**Our Ref: BR/318/13/
Your Ref:**

**Town & Country Planning Act 1990 (as amended)
Town and Country Planning (Development Management Procedure) (England) Order 2010 (as amended)
Application for Planning Permission**

Development Placement of Biomass cabin and pellet store to rear garden including pipework.
Location Abbeyfield Society 9 Richmond Avenue Bognor Regis

Client: Abbeyfield Bognor Regis Society
Location: Bognor Regis
Project: 2 x ETA 90Kw Biomass
Drawing Title: Elevations / Pipe Run

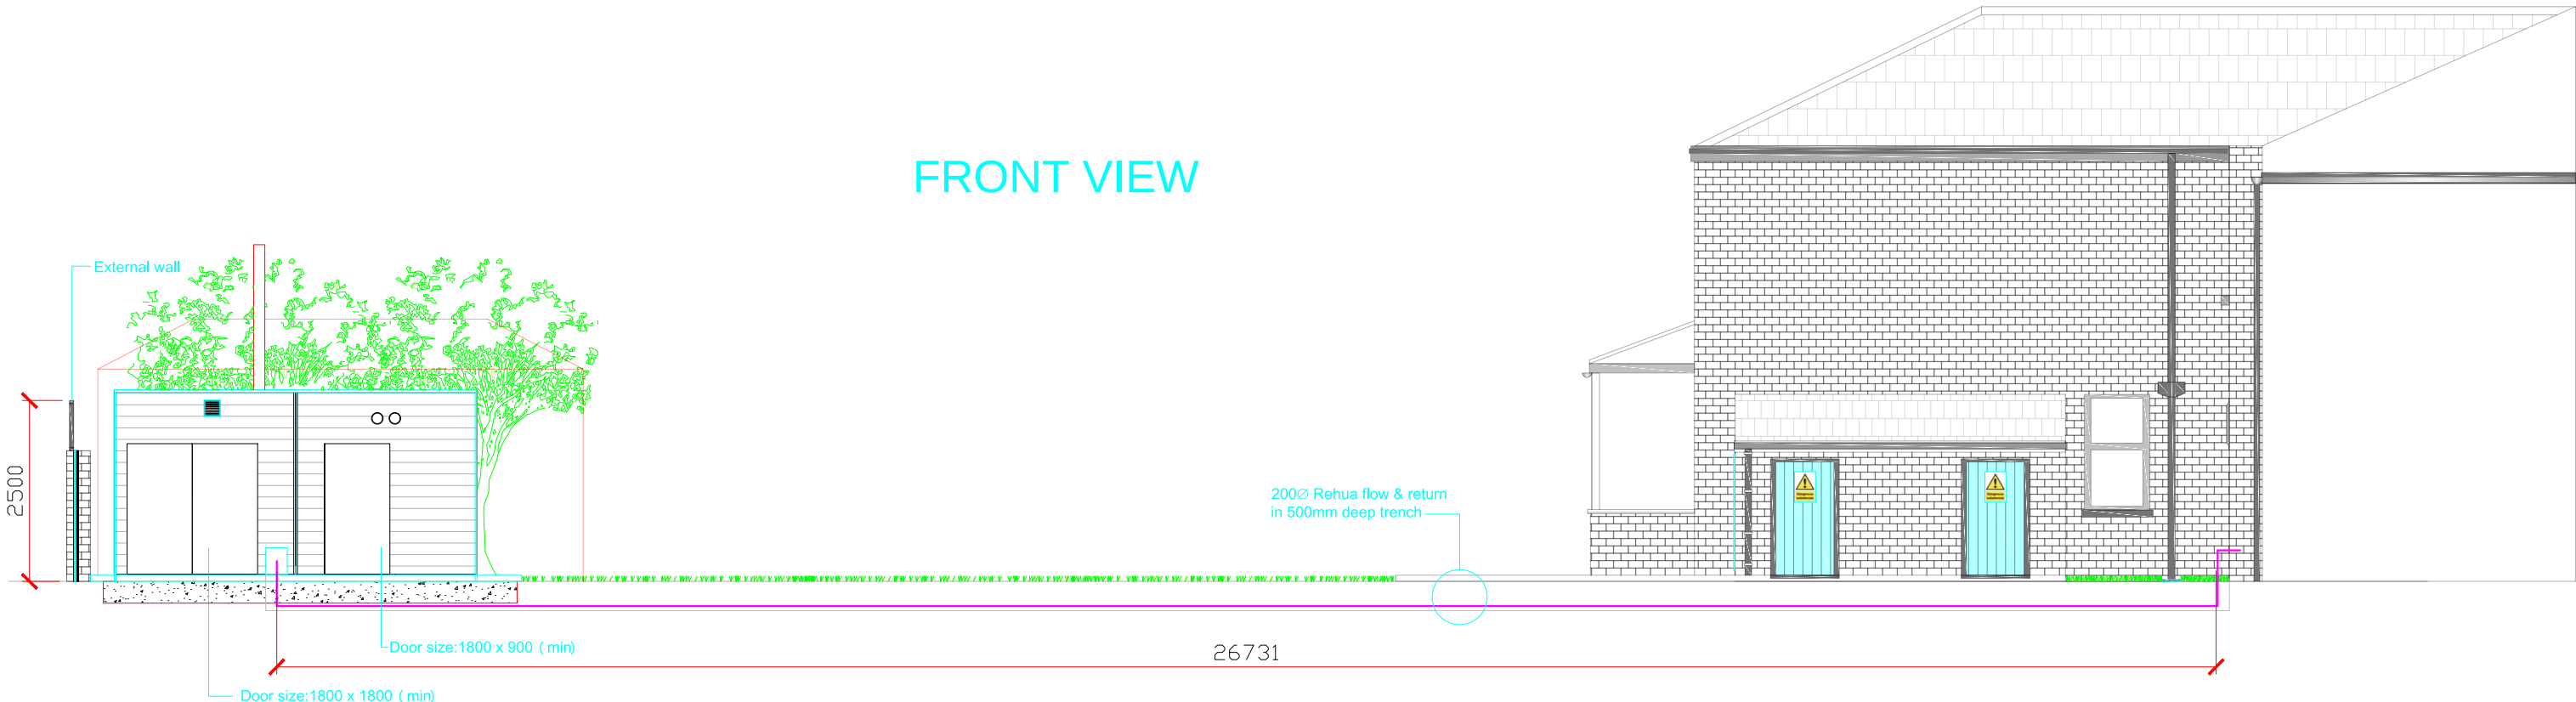
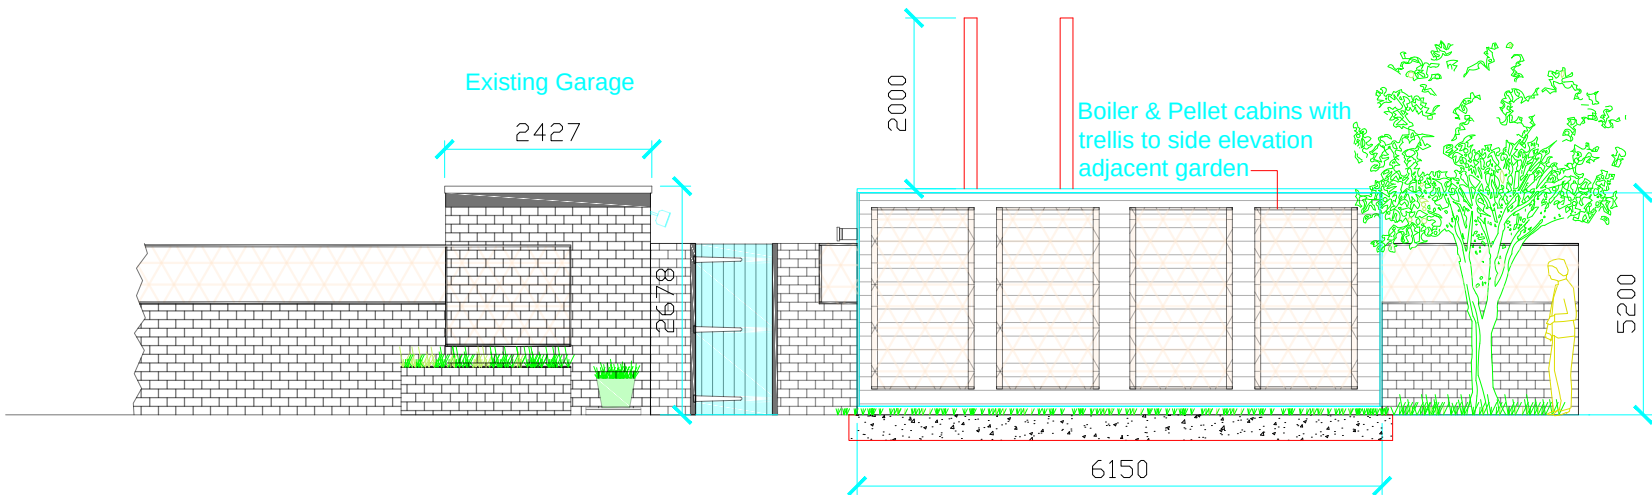
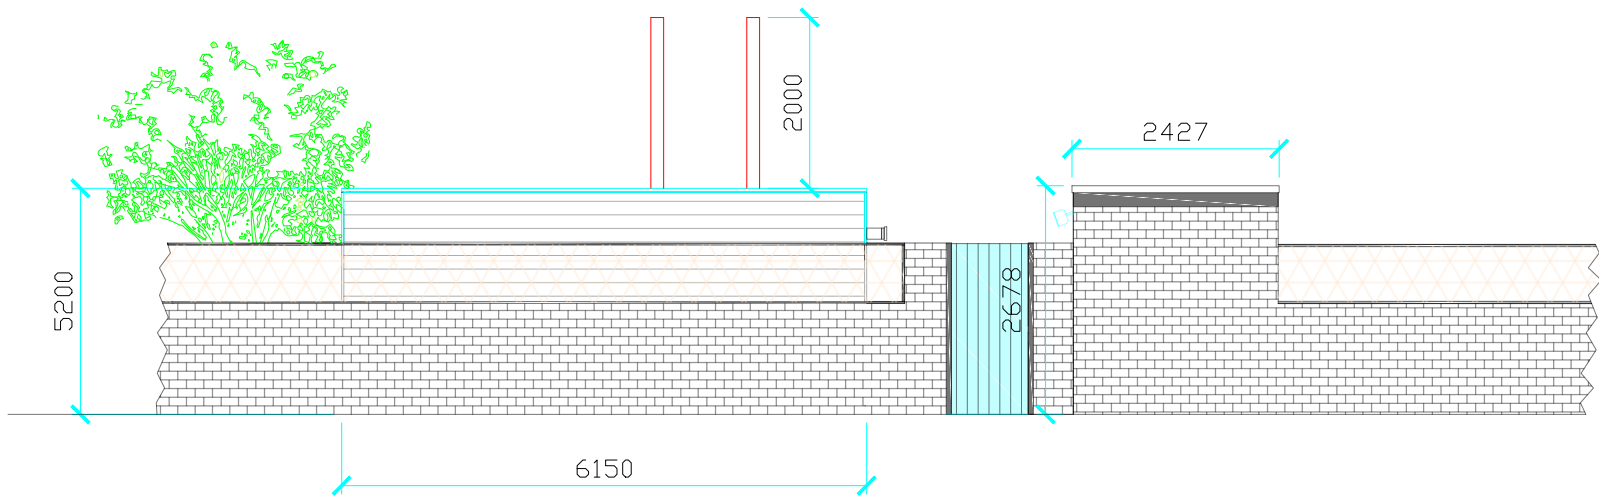
The floor plans and elevations do not scale properly.

Please provide a plan showing the rear elevation.

PLAN VIEW

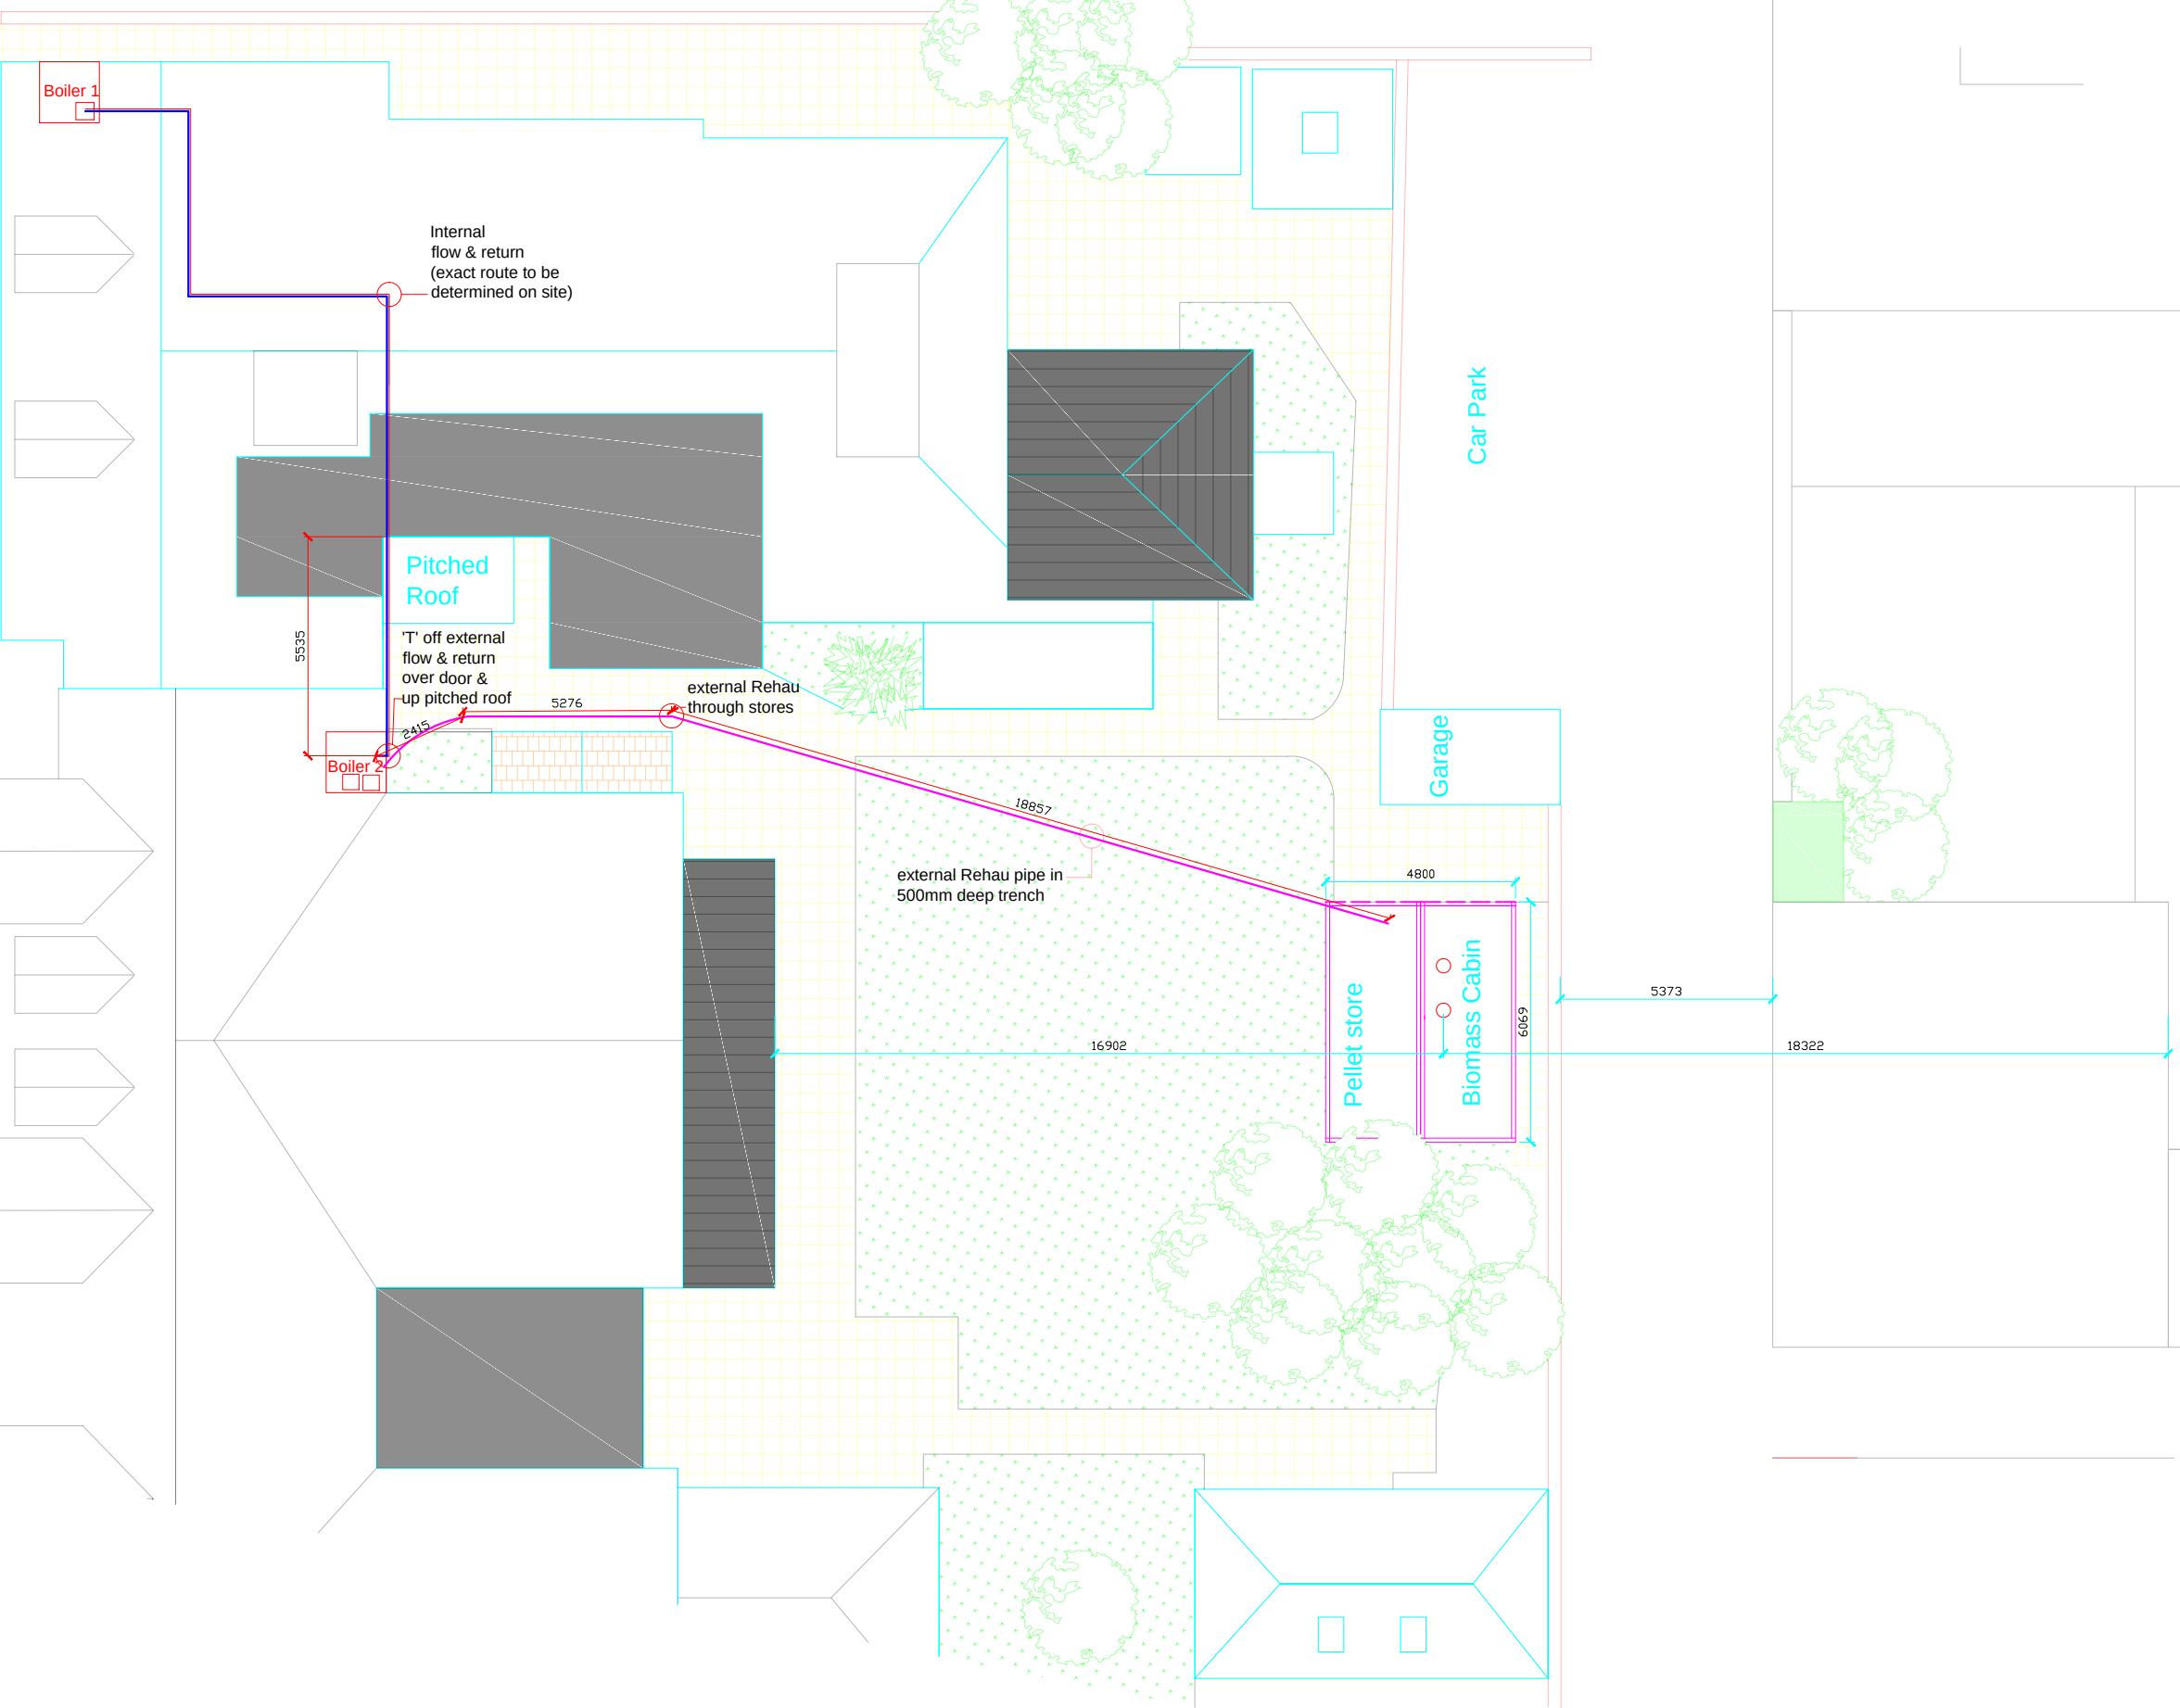
Please provide a plan showing the proposed floor plans.

The provided plan view shows that the property to the East of the site is attached to the site while the location and block plan show that the property is semi detached. Please either amend the plan view to show that the property is semi detached or provide an up-to-date location and block plan to show the properties are attached.

# Abbeyfield

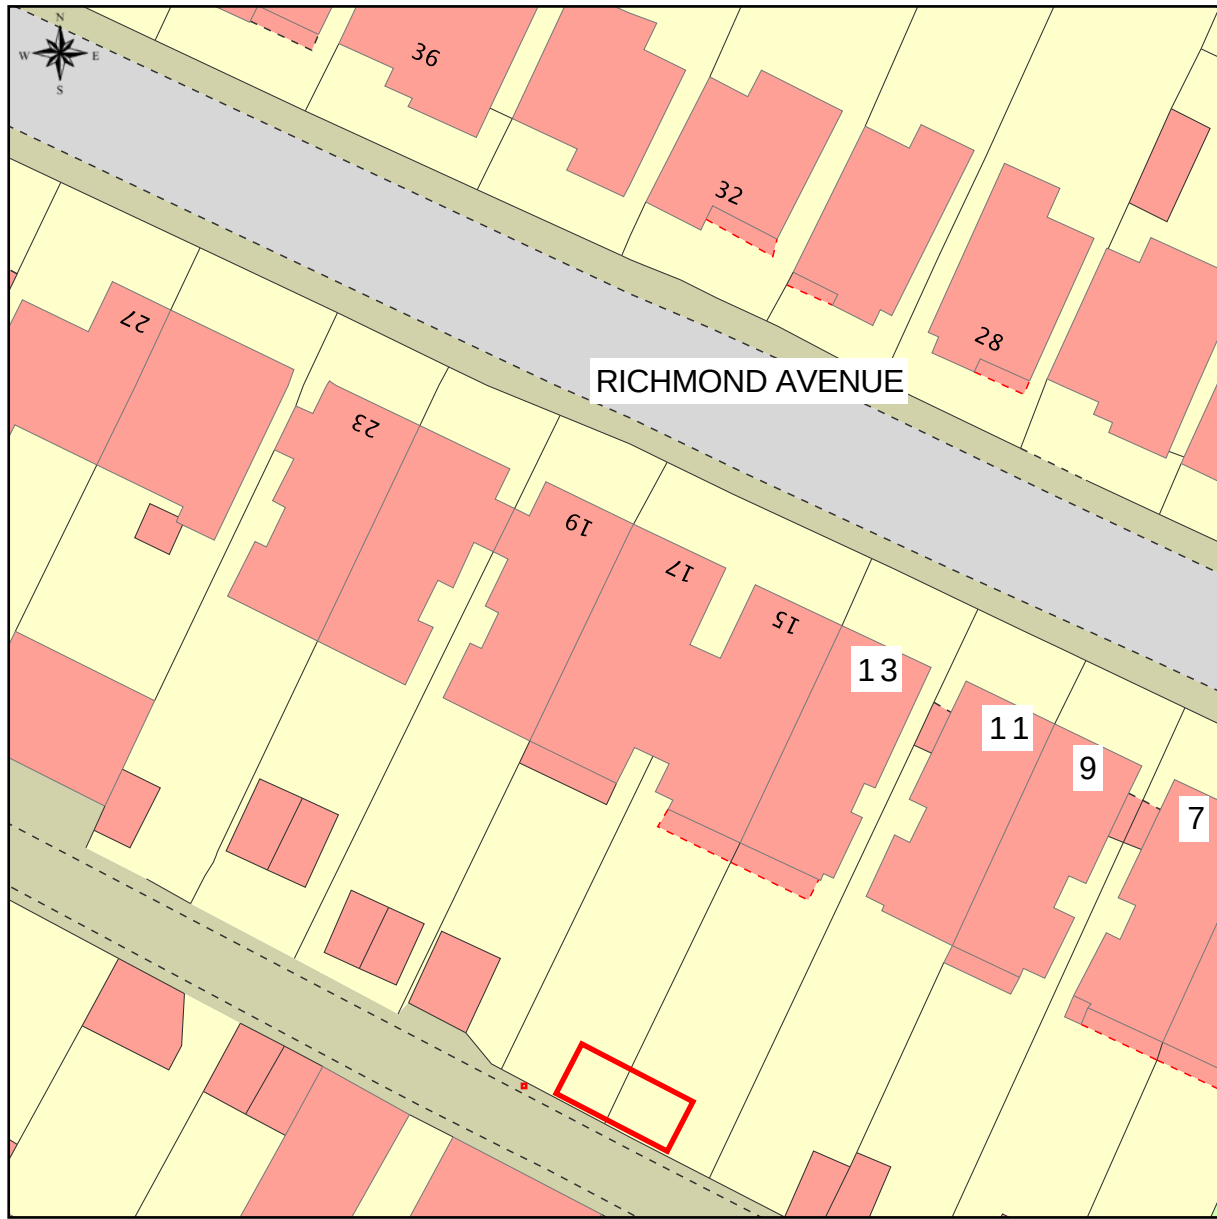
Please submit 1 electronic or 3 paper copies of a block/site plan at a scale of 1:500 or 1:200. Further details of what must be included on the plan can be found in the National Validation Requirements. Please provide one named road and provide the measurements from the proposal to the site boundaries.

The blue edge on the Location plan does not match the blue edge on the Block plan. Please amend accordingly.

location plan and block plan shows the proposal in the rear garden of 15 and 17 Richmond Avenue. Please amend accordingly.

Abbeyfield Bognor Regis Society Biomass

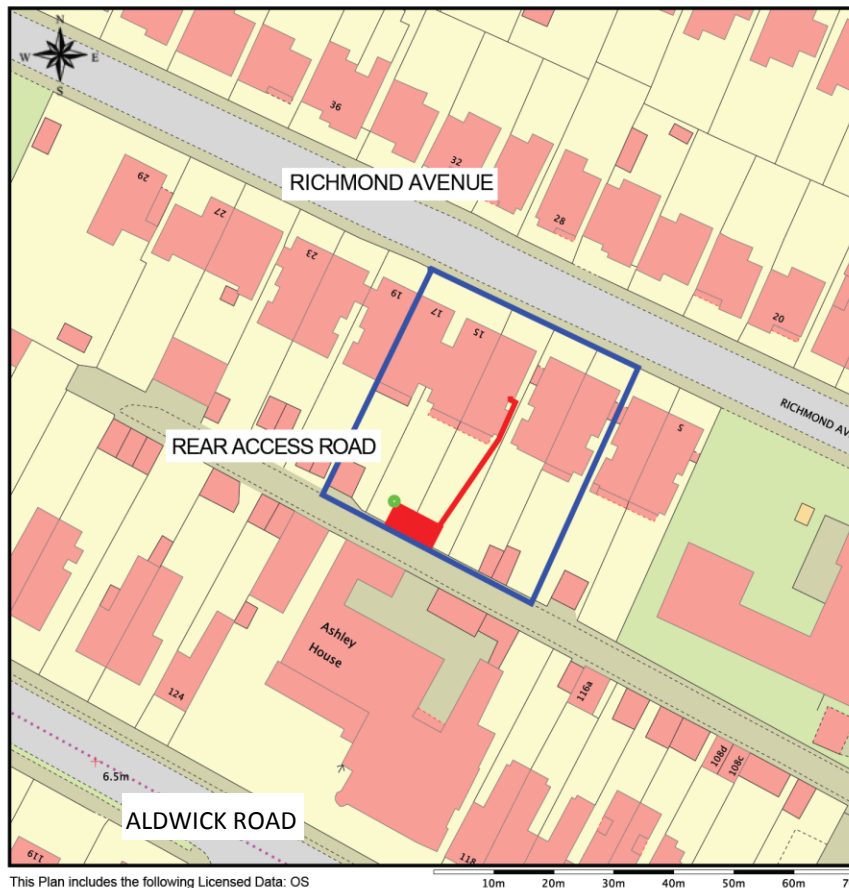
Please submit 1 electronic or 3 paper copies of a location plan at a scale of 1:1250 or 1:2500 for rural areas. Further details of what must be included on the plan can be found in the National Validation Requirements. Please provide another named road.
